From: Graham, Laura 
Sent: 19 June 2017 18:06
To: Michael Eastham
Cc: Claire Potts
Subject: FW: Fitzalan Link - LU.234.16.RES

Subject: RE: Fitzalan Link - LU.234.16.RES

In summary, there appear to be just three outstanding points now – the choice of road surface, the requirement for a new or supplementary Stage 1 Road Safety Audit and the design of the shared footpath-cycleway connection to Highdown Drive close to the new Toucan crossing now proposed. The other points can be tied-into the detailed S38/S278 submission.

rev.
P5

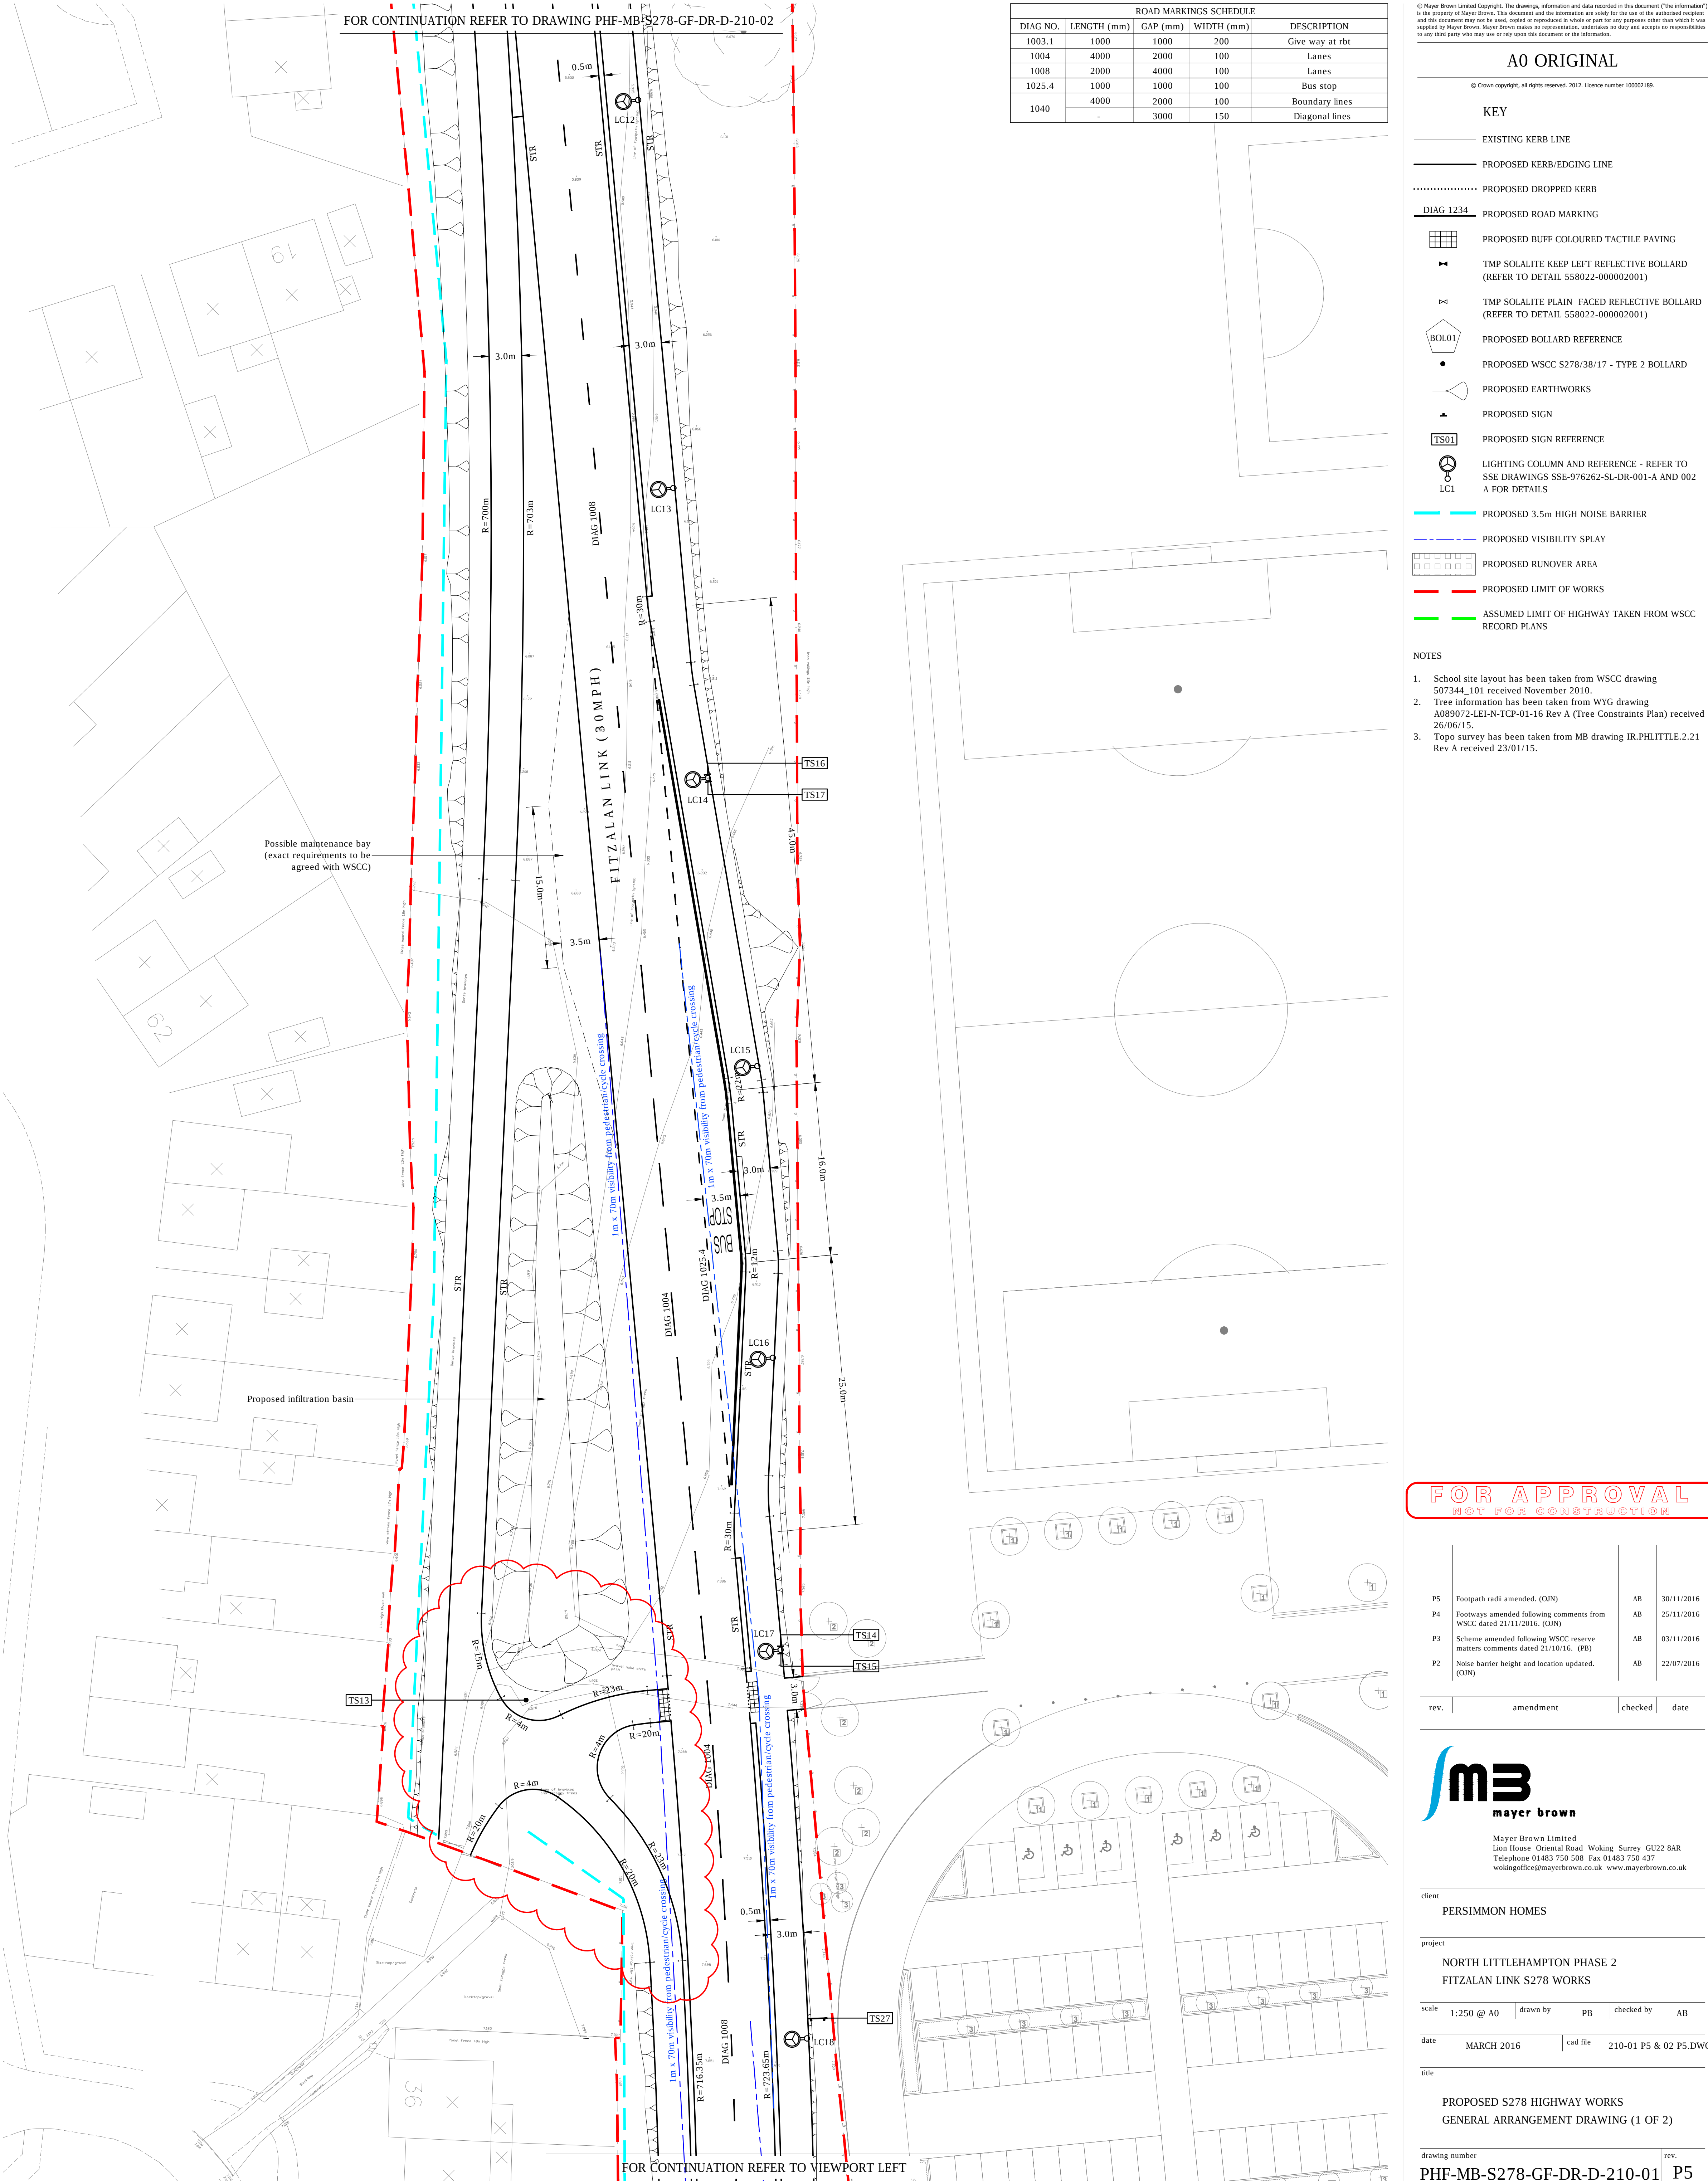
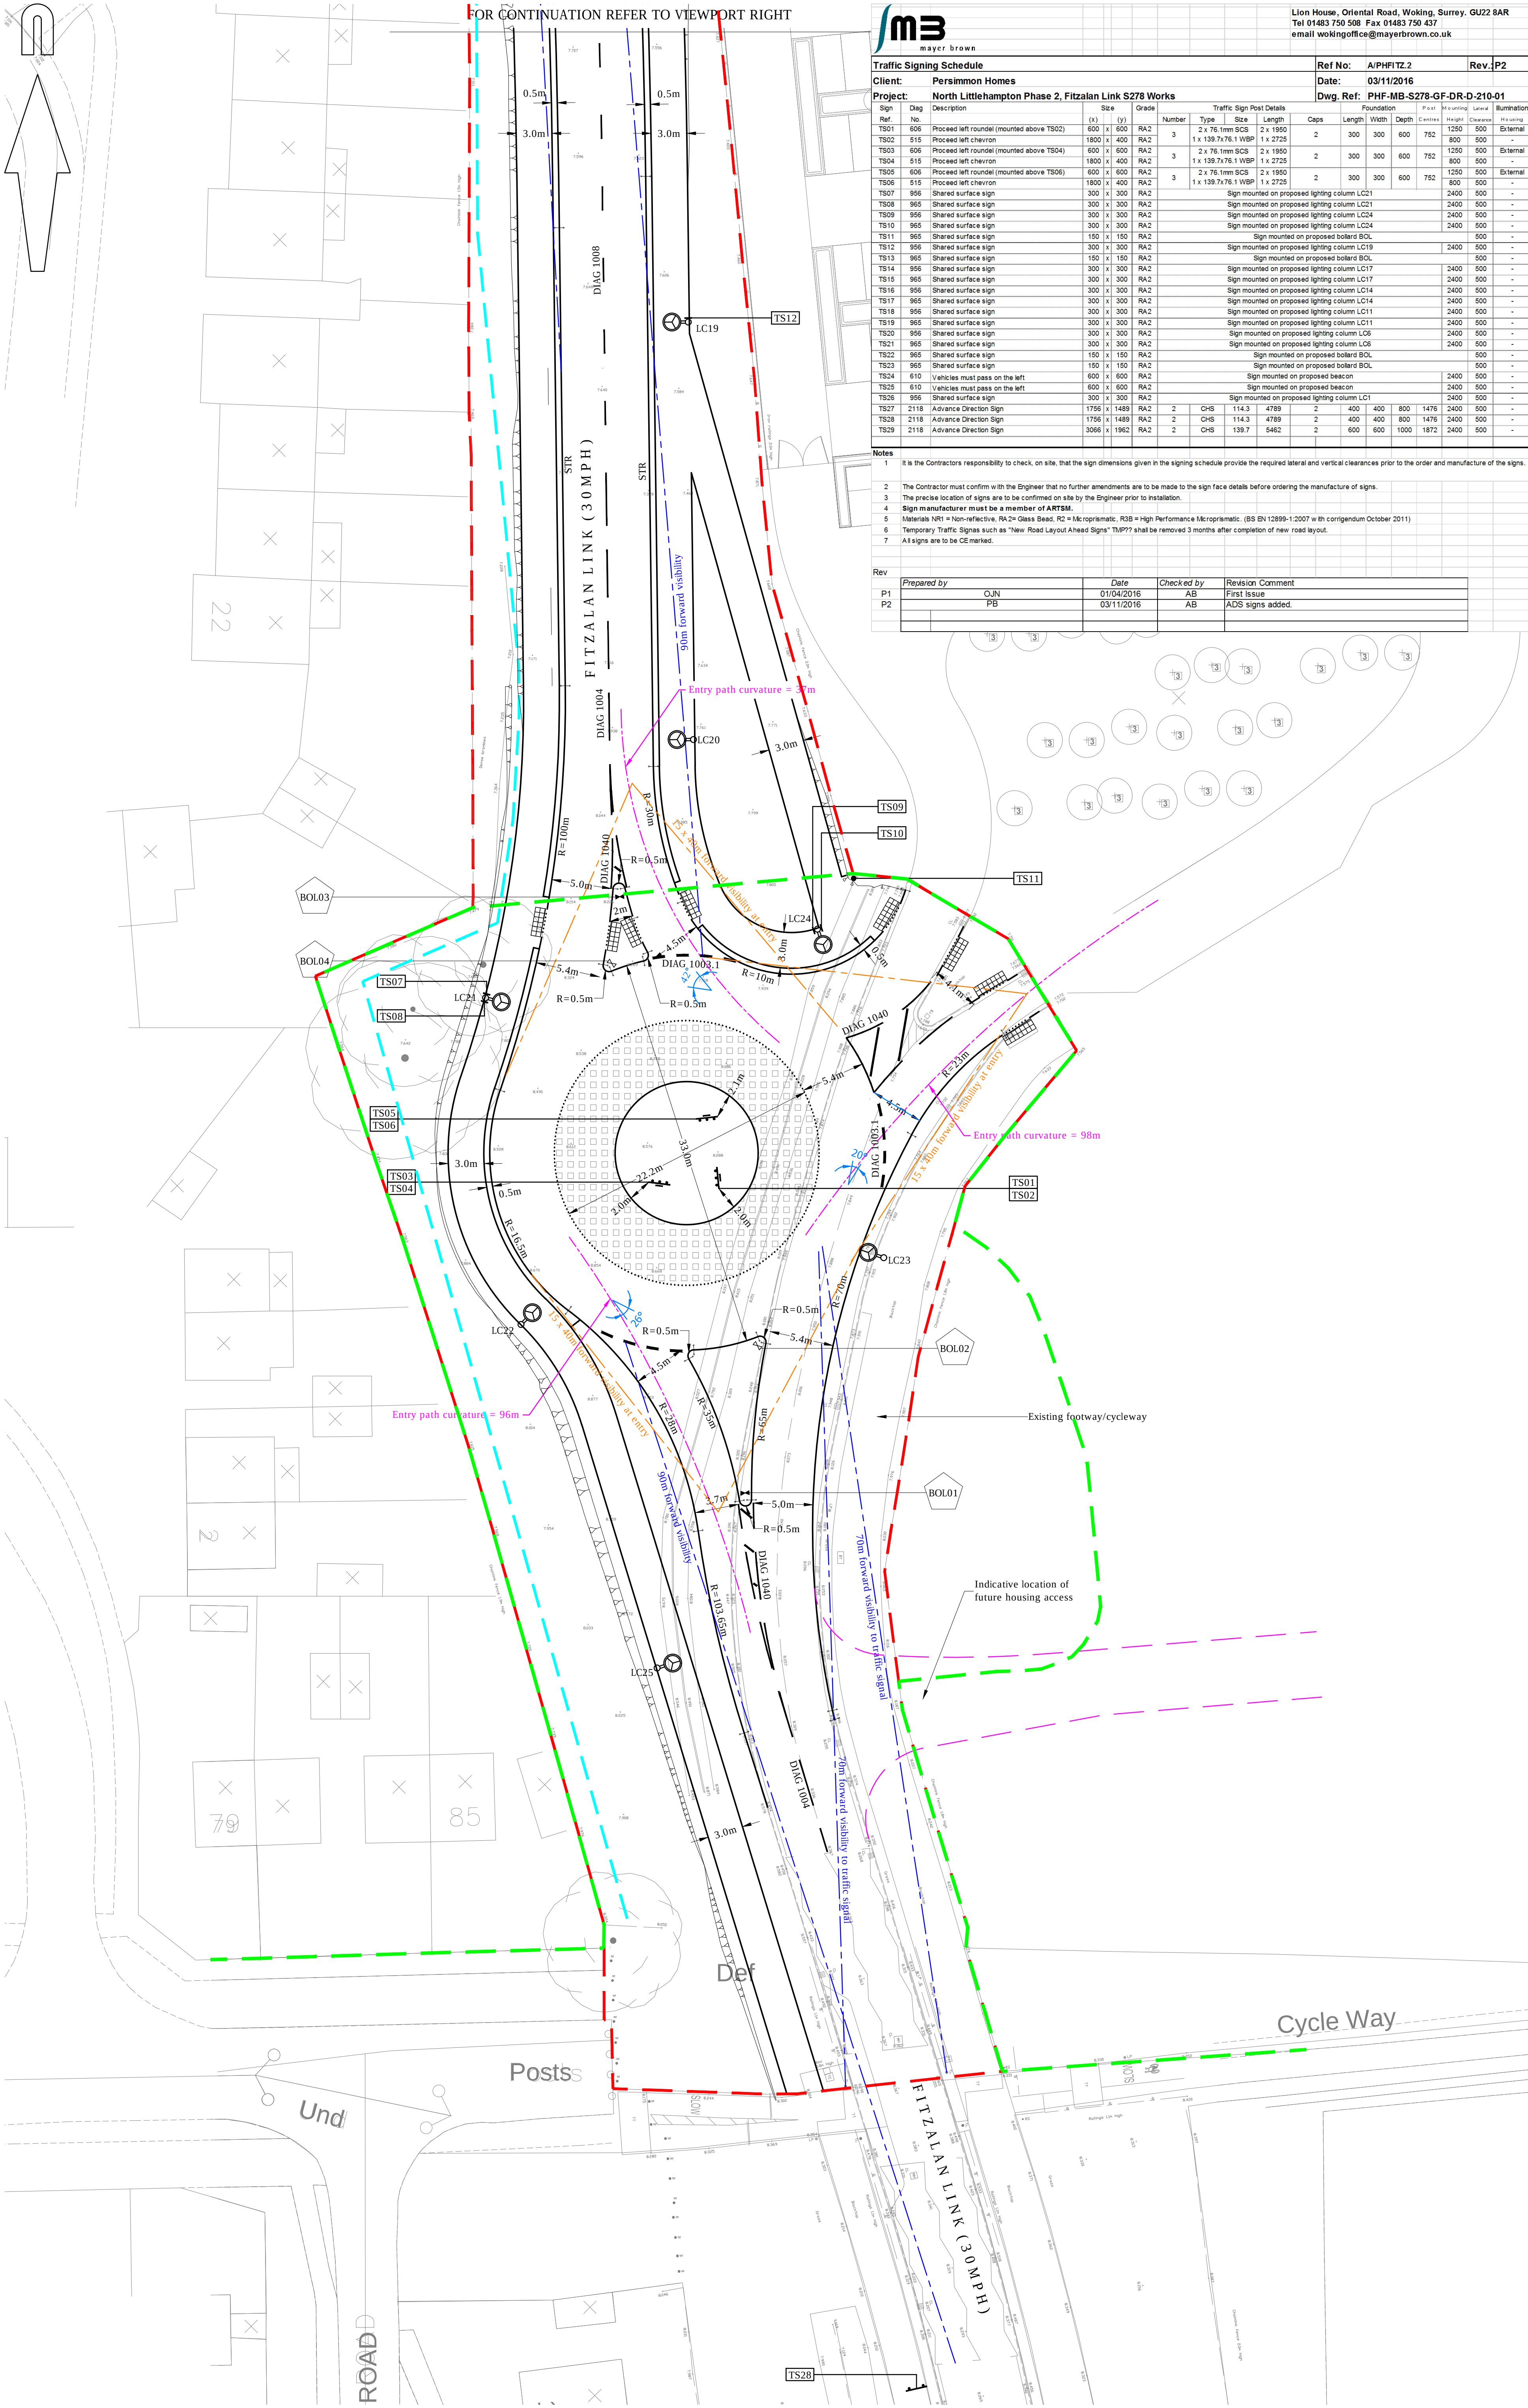
The drawings show a pervious road surface. This will not be long lasting enough. The best WSCC can consider is a negative textured road surface. However, this will not absorb as much noise. Your designer will need to look into "German SMA" which is an SMA with a high binder content and use an appropriate noise reduction factor.

Academy roundabout northern traffic island has a tactile paved crossing point. Given that it is narrow (the tactile paving on the drawing appears to 'meet'), consideration should be given at the S38/S278 stage to widening it or adjusting the position of the tactile paving (if possible) to improve width for pedestrians. However, in doing this you should also ensure that the swept-path of vehicles can still adequately negotiate the roundabout without compromising safety for pedestrians on the island.

Recommend that at the detailed design stage, the cycleway on the east side be locally flared at the controlled crossing to provide additional width for waiting pedestrians and cyclists. Also, that LC 17 be moved to the very back of the space available, away from the area of conflict where there would be interaction between pedestrians and cyclists. WSCC recommended to increase the crossing width beyond the minimum so as to provide more space for waiting pedestrians in order to help keep the cycle route clear. The location of the control box must be carefully considered to avoid obstruction for users and visibility. Finally, it is recommended that corner radii be applied between the cycle paths at the school exit next to the crossing and that pedestrian and cycle intervisibility is provided at this location.

Thank you for showing a northbound bus stop and layby. Where possible (and again at the detailed design S38/S278 stage), additional path width should be provided at *both* bus stops to allow passengers to wait clear of the cycle path. Also, please consider where bus shelters might be placed, and what form these would take given the space available.

We sought to reduce carriageway of the road to 6.75m as this would have the effect of constraining speed closer to the proposed 40mph speed limit requested by WSCC. As a result, HRA (standard surface) could be provided. Our noise consultants have assessed the impact on noise relating to a speed limit of 40mph and with a HRA surface course finish (standard / noisiest surface) and this includes that speeds of 42mph would be okay in terms of the noise assessment submitted and enable a 3.5m noise barrier to provide sufficient noise mitigation. WSCC's 2010 speed policy refers to an average speed of 42mph for a 40mph road. Thus the above would appear appropriate.

Noted. We shall review to see what changes can be made to accommodate a larger island as requested.

Noted. We shall review to see what changes can be made.

We have been clear that space is restricted to provide this late edition facility (which we are doing to accommodate an WSCC oversight on the section of the Link Road they have already delivered) . We 'may' be able to provide an increased width footway of 3.5m on the western side, but we will need to review the levels so this can not be guaranteed and should not be used as a means to hold up this application. Otherwise, if the footpath width is crucial then we will not be able to provide a bus stop at all. In terms of bus shelters we can provide one but is likely to restrict foot / cycle path width even more. Furthermore, this seems a bit onerous given that the outline doesn't actually require us to provide a bus stop. We consider that an open bus stop is appropriate, especially given the width restriction and if a shelter becomes necessary at a later stage WSCC could fund this with wider infrastructure contributions.
